Engineers Comments Regarding Surface Water Drainage

Application Reference:	P/46/25/DOC	Reviewer Reference:	ADC/SB
Planning Officer:	Jessica Riches	Date of Review:	30/07/2025
Site Name:	Land South of Summer Lane and West of Pagham Road Pagham		
Application Description:	Approval of details reserved by condition imposed under reference P/140/16/OUT relating to condition number 4 - detailed scheme of phasing , condition number 5 - schedule of materials and finishes, condition number 17 - Construction Management Plan and condition number 24 - energy.		
Assessment Number:	1 of 2

Condition 4: Objection

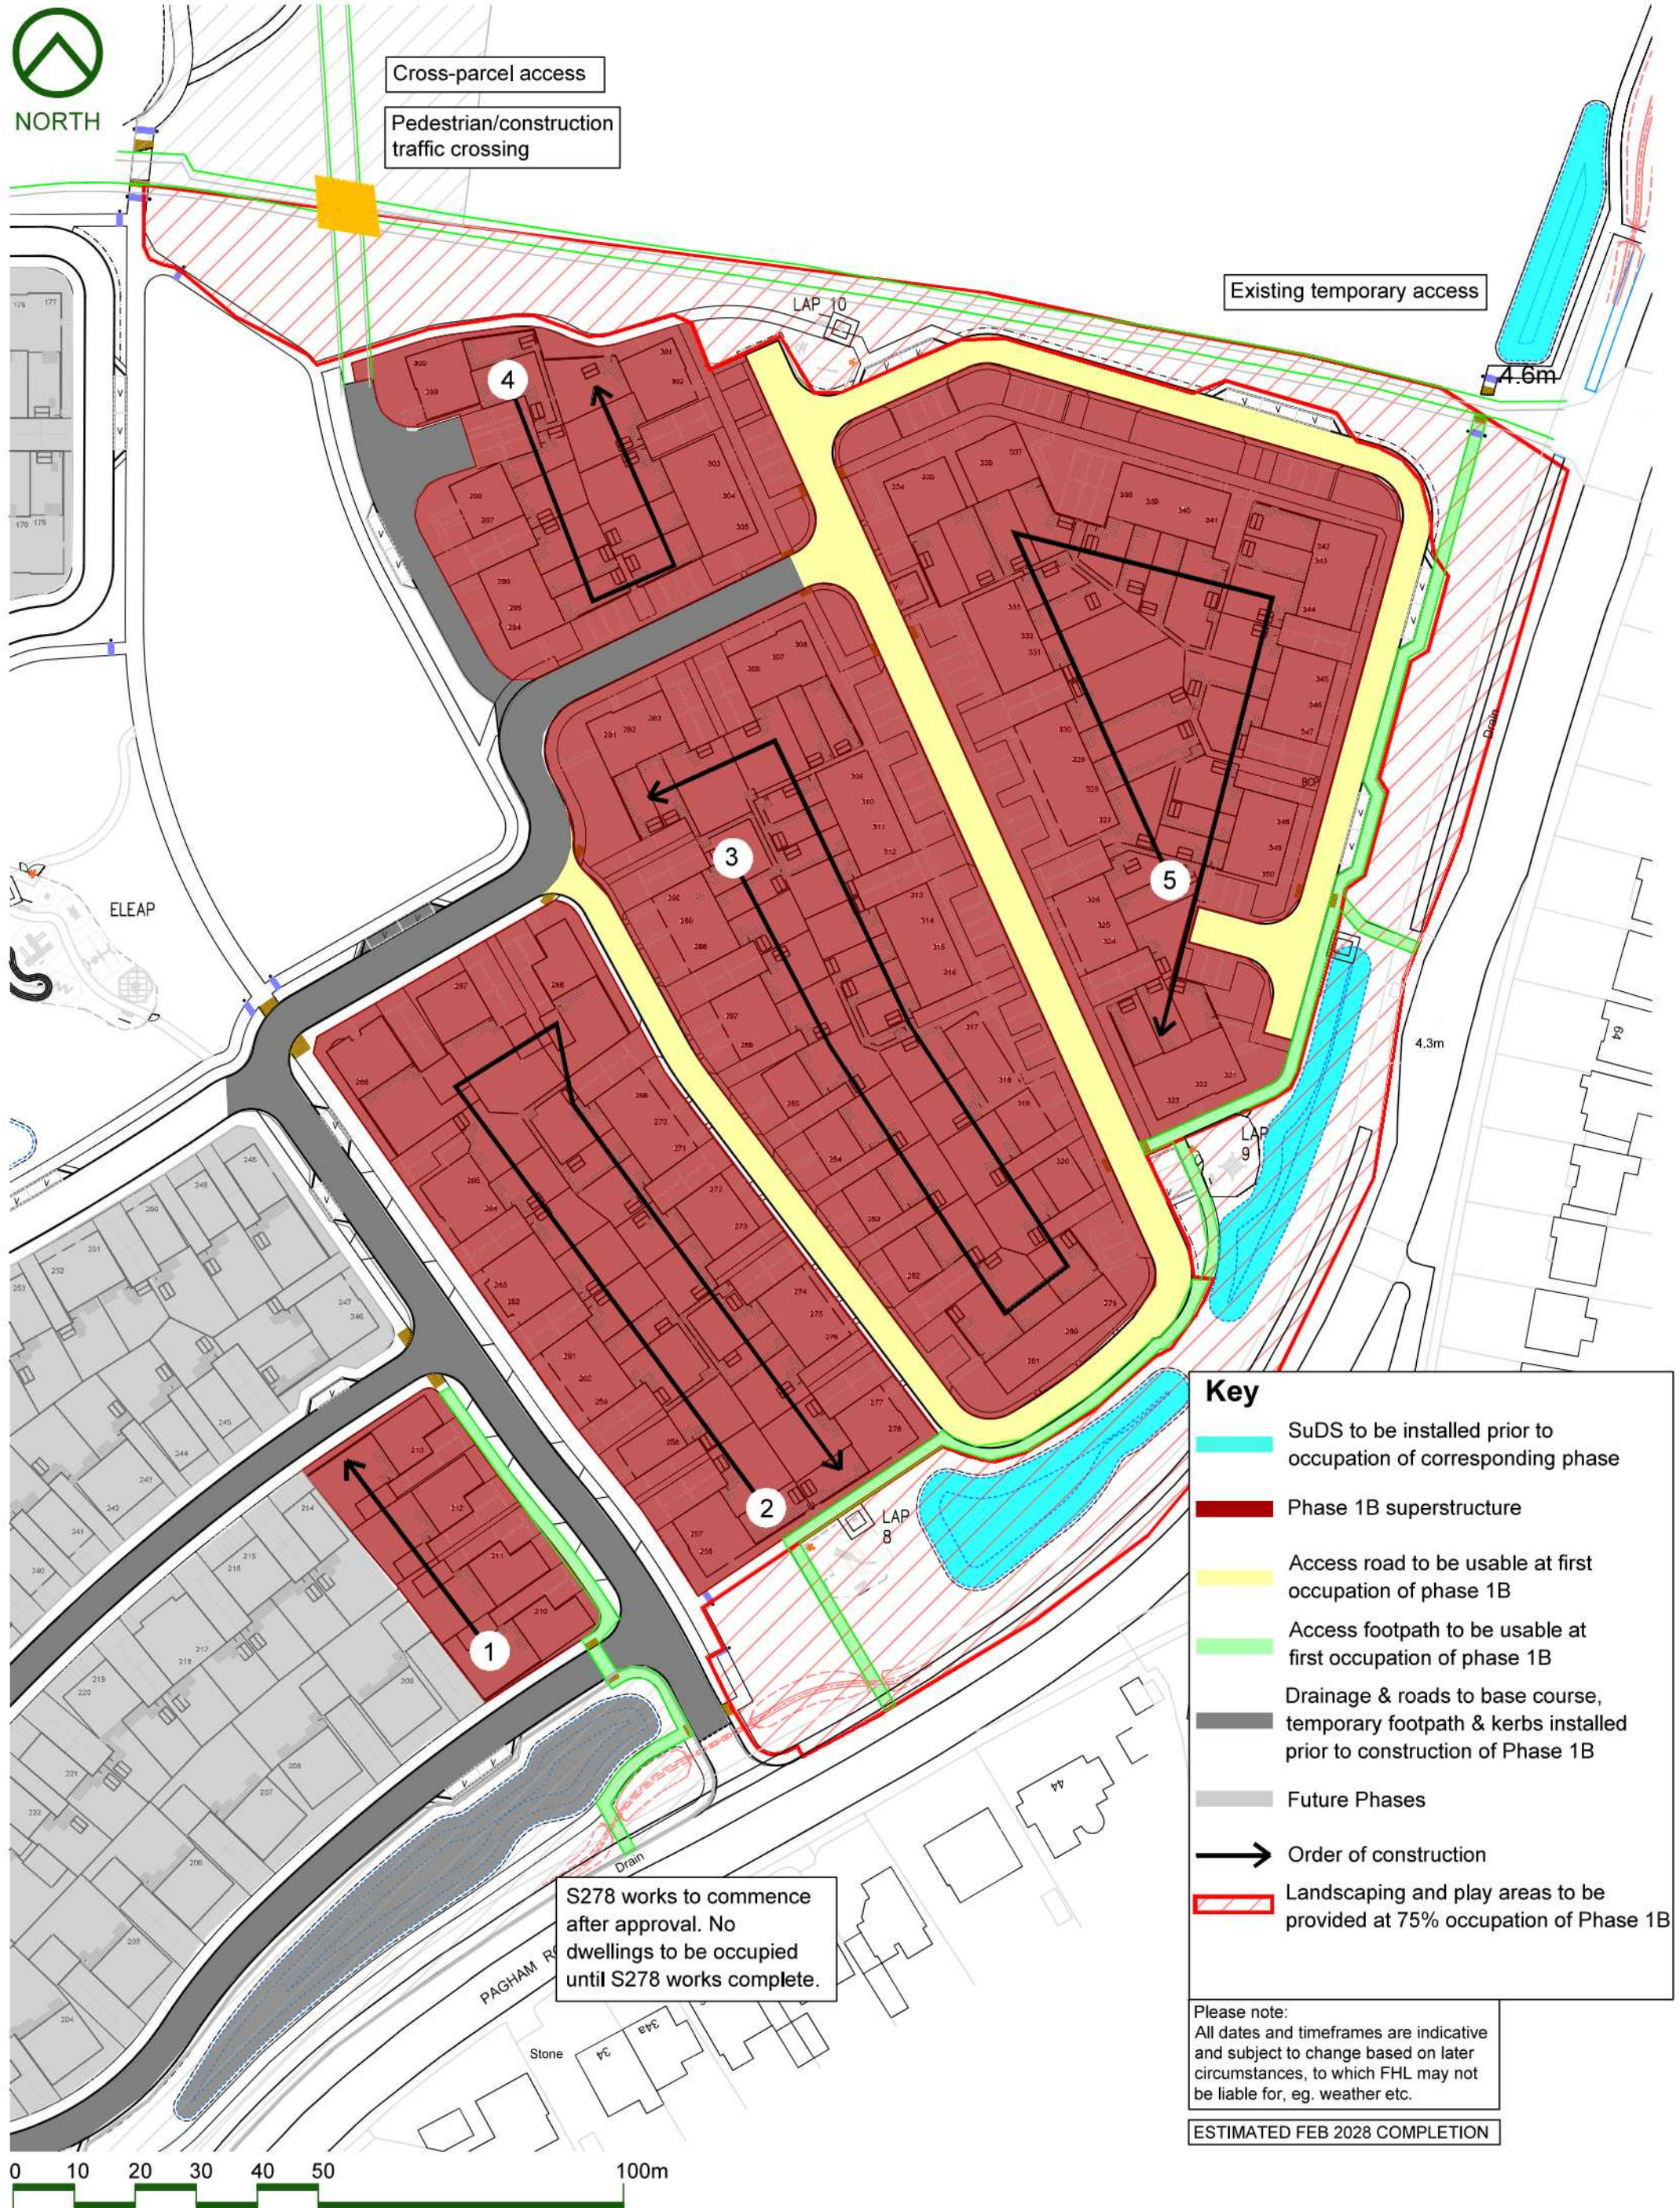
The site phasing plans state that SuDS are to be installed prior to occupation of corresponding phase. This is not acceptable as it could result in significant construction having been completed and inadequately drained as it is not technically occupied. This could lead to an increase in flood risk and pollution during the construction of the site. Temporary drainage to manage flood risk and silt (pollution control) must be constructed prior to any further construction in that phase, then if those temporary drainage features are to be permanent then they must be remediated prior to occupation of the final dwelling in the phase.
